I-2513 B & D 4B Meeting Minutes

I-2513B&D Concurrence Point 4B Meeting

Date: June 18, 2025
Location: CCA Structures Conference Room
Time: 1:00PM
Attendees: Hannah Headrick – NCDOT
John Jamison – NCDOT (Teams)
Todd Lapham – NCDOT
Carlos Sharpless – NCDOT (Teams)
Yates Allen – NCDOT (Teams)
Jennifer Parish – NCDOT (Teams)
Daniell Bagley – NCDOT (Teams)
Scott Jones – USACE (Teams)
Lori Beckwith – USACE (Teams)
Holland Youngman – FWS (Teams)
David Moyar – JV (Teams)
Byron Holden – RK&K
Jeremy Keene – RK&K
Pete Stafford – RK&K (Teams)
Chris Rivenbark – RK&K
Vidya Mohandas – WSP
Kase Schalois – WSP
Chris Lewis – TGS (Teams)

The Hydraulic Review was held in order to reach compliance on Merger Concurrence Point 4B, further known in the minutes as 4B, for I-2513B&D, I-26 / I-240 in Buncombe County. The following items were discussed and conclusions reached:

SITE 3

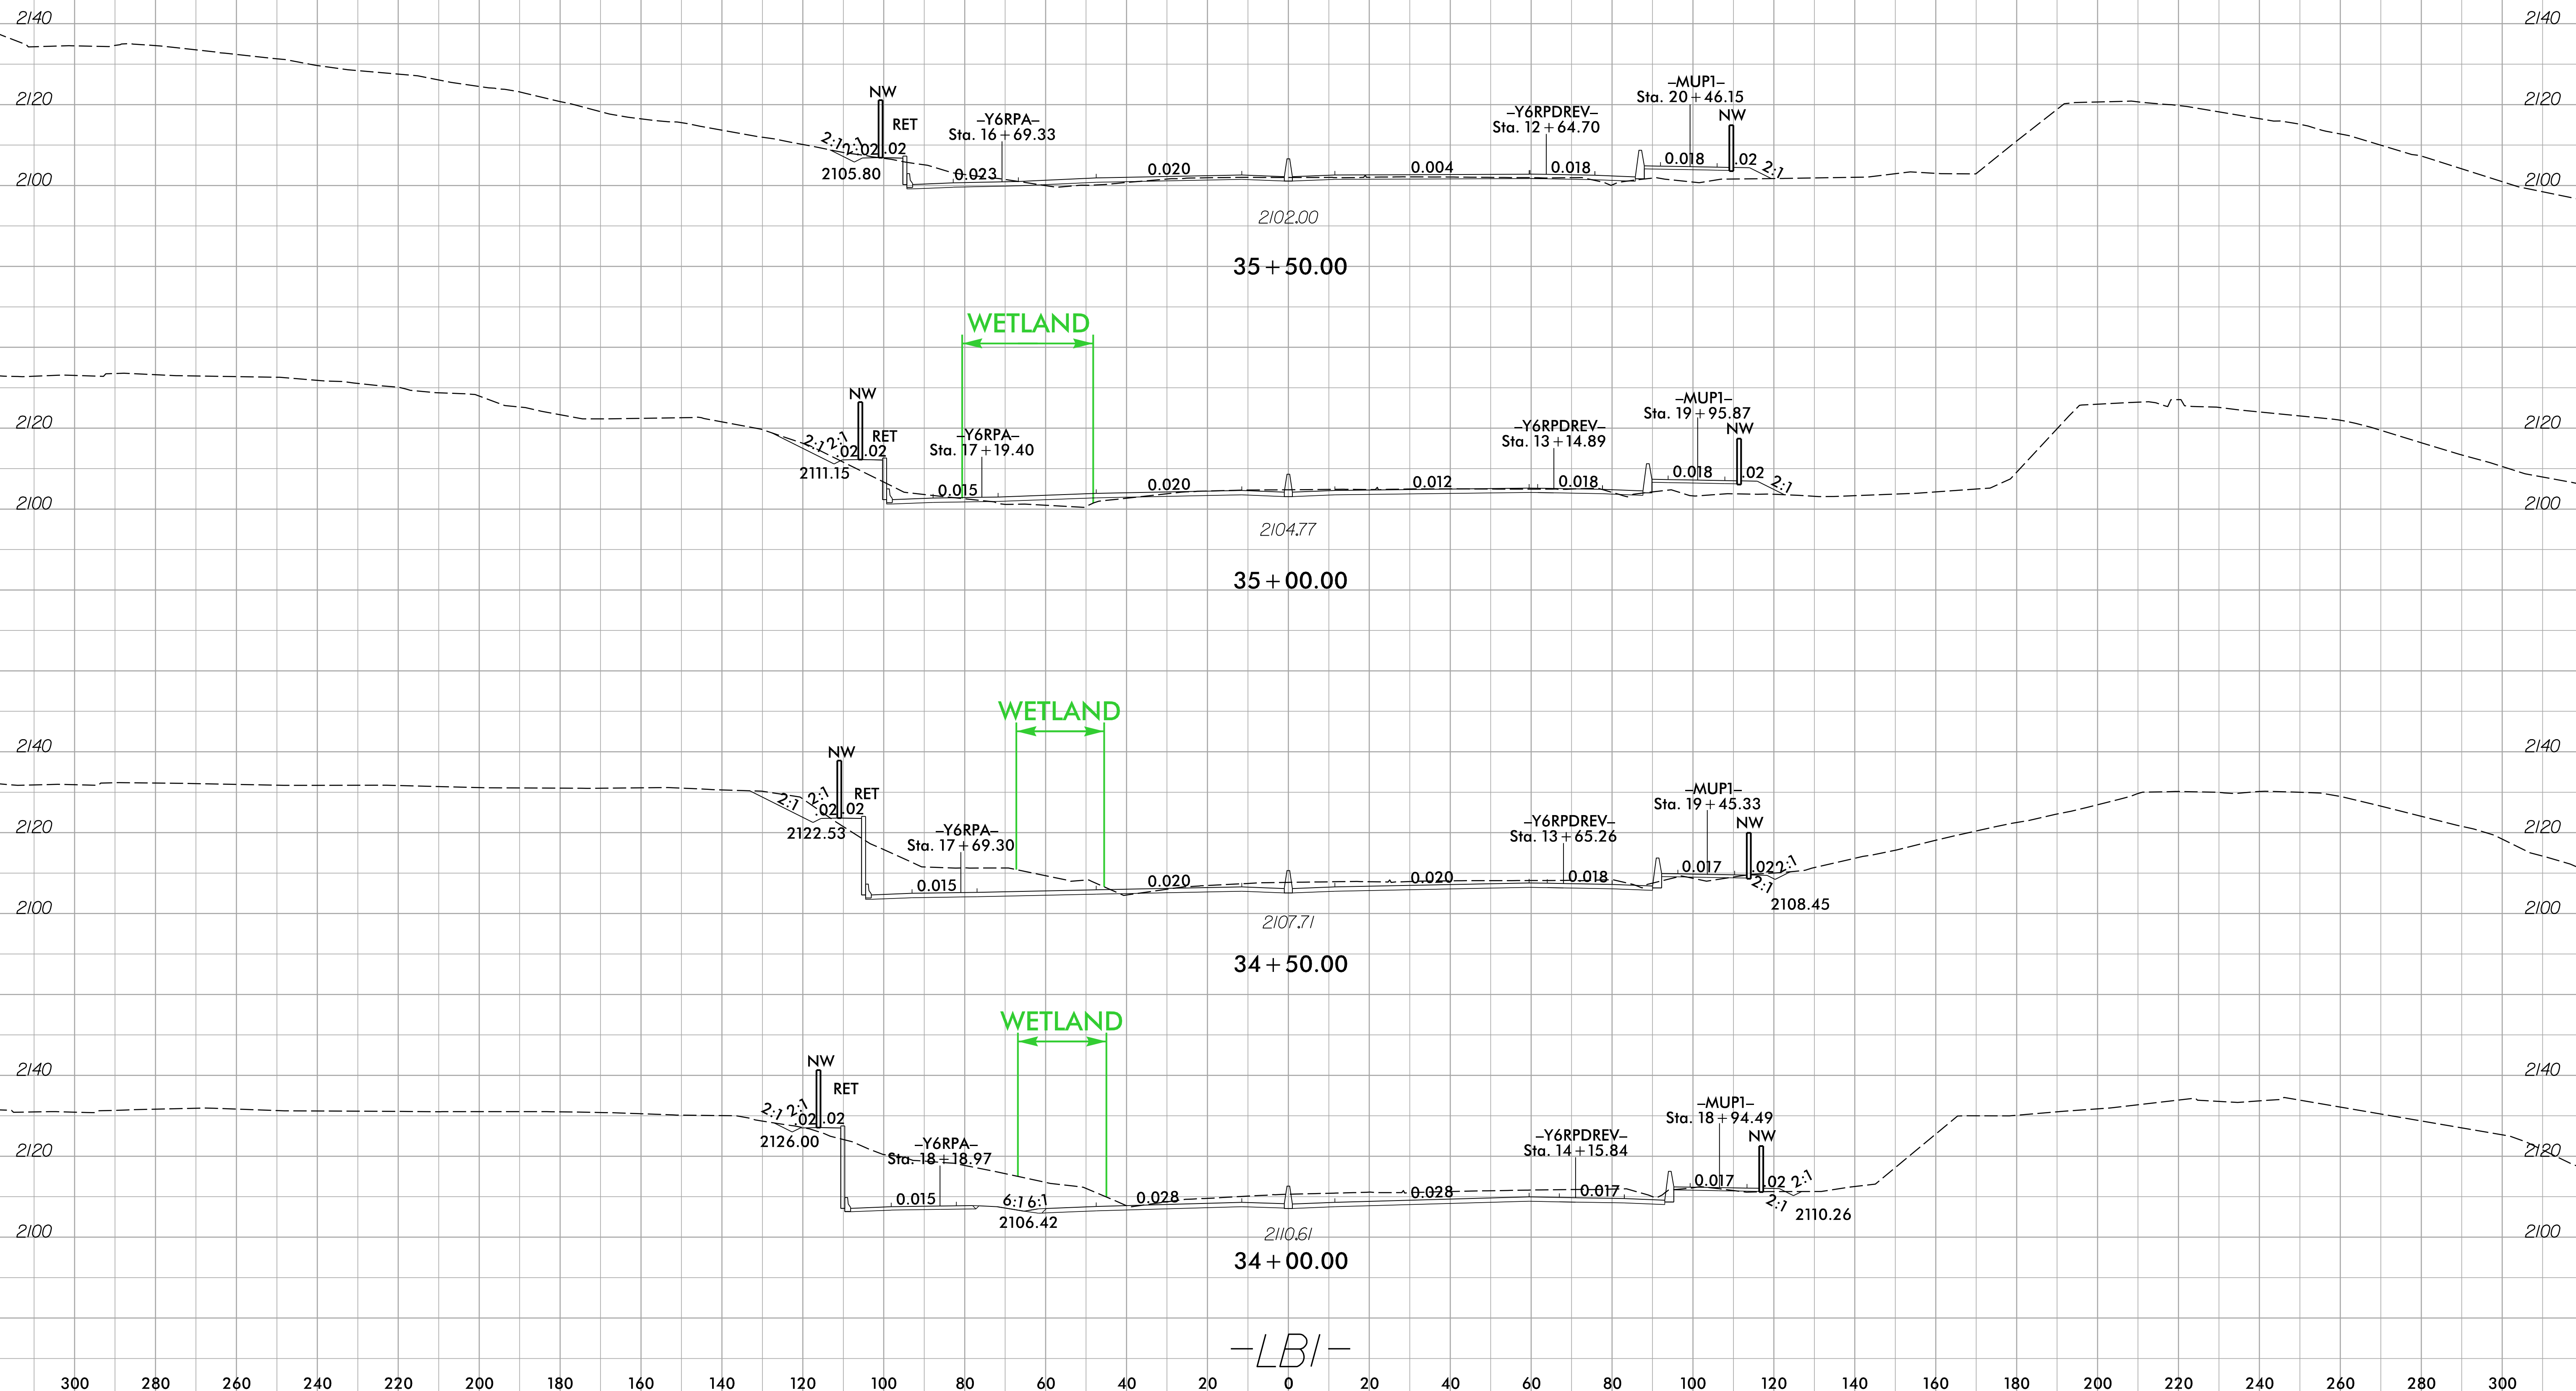
- Wetland WF/WF2 is Permit Site 3 in the preliminary permit.
 - This site is completely covered by roadway fill so it will be a total take.
- Tributary TBG was identified by RK&K since the preliminary permit.

**PERMIT DRAWING
SHEET 26 OF 81**

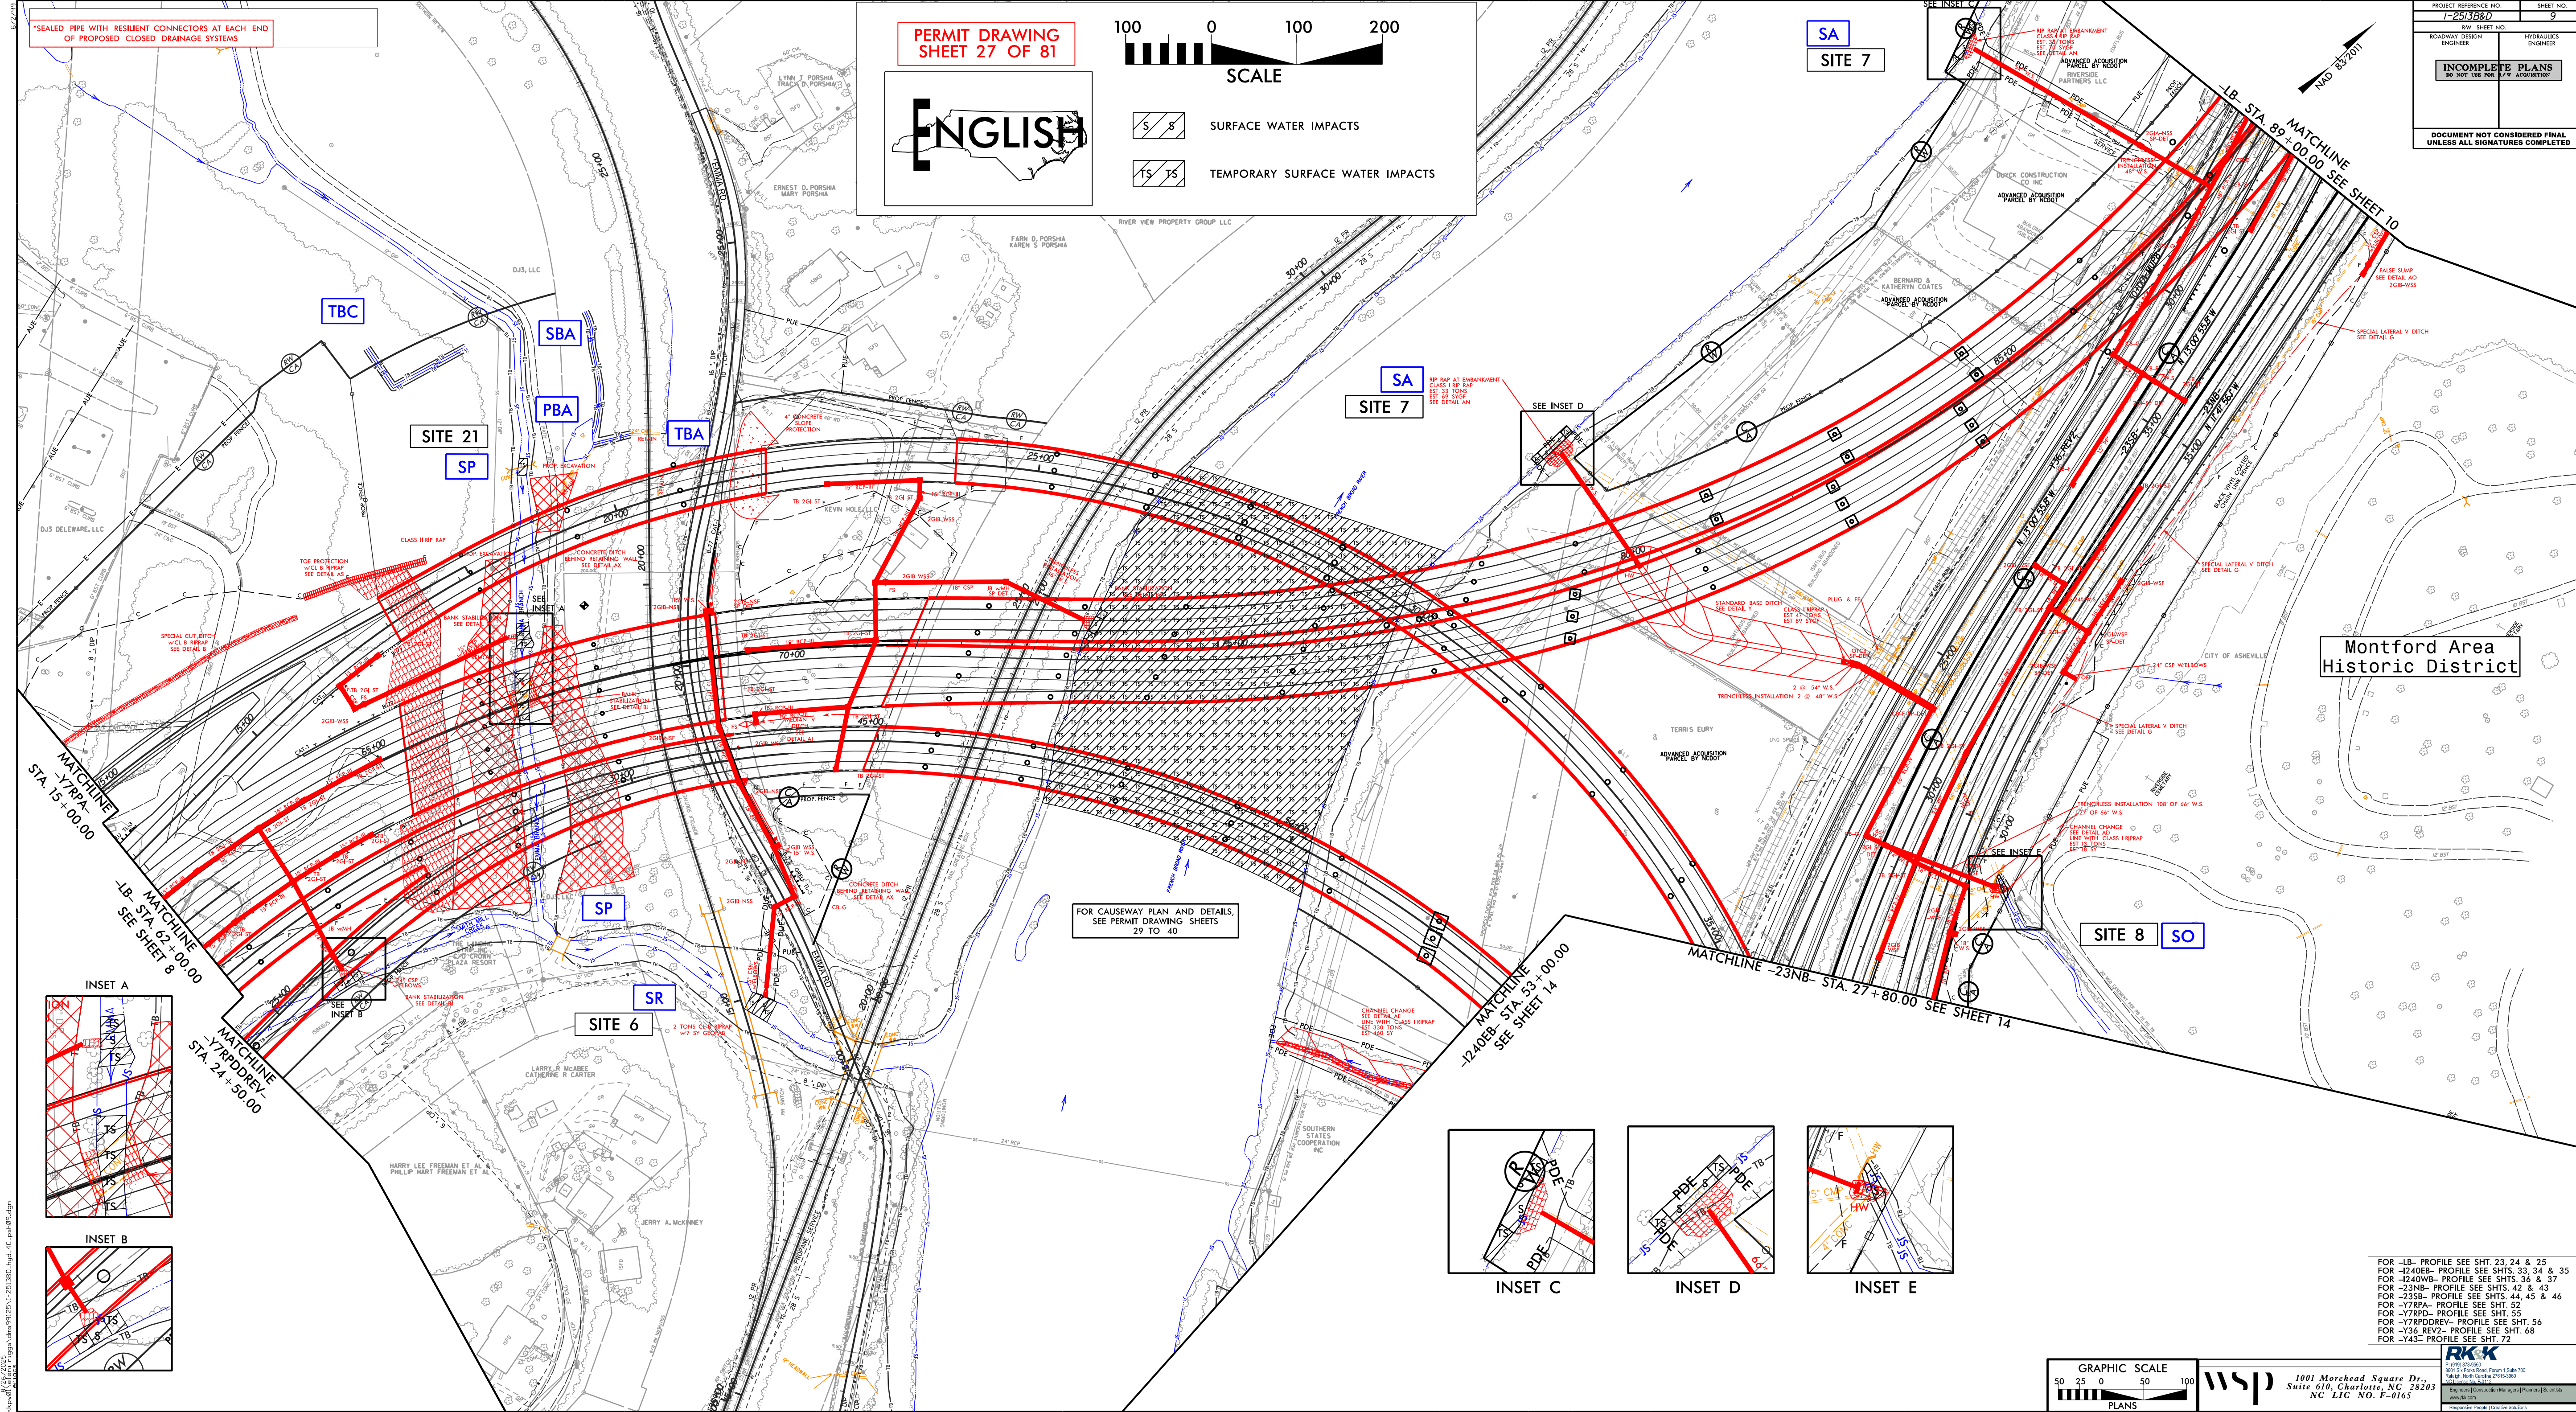
- Stream SS is Permit Site 5 in the preliminary permit.

- SS is currently fed by tributary TBE and wetland WBA. Both the tributary and the wetland will be covered by roadway fill, so even though a large portion of stream SS is not covered by roadway fill, it will be considered a total take due to loss of hydraulic viability.

- Wetland WBA was identified by RK&K since the preliminary permit.
 - This new wetland is adjacent to stream SS, so Mr. Cook proposed to add it to Permit Site 5 and everyone agreed to this.
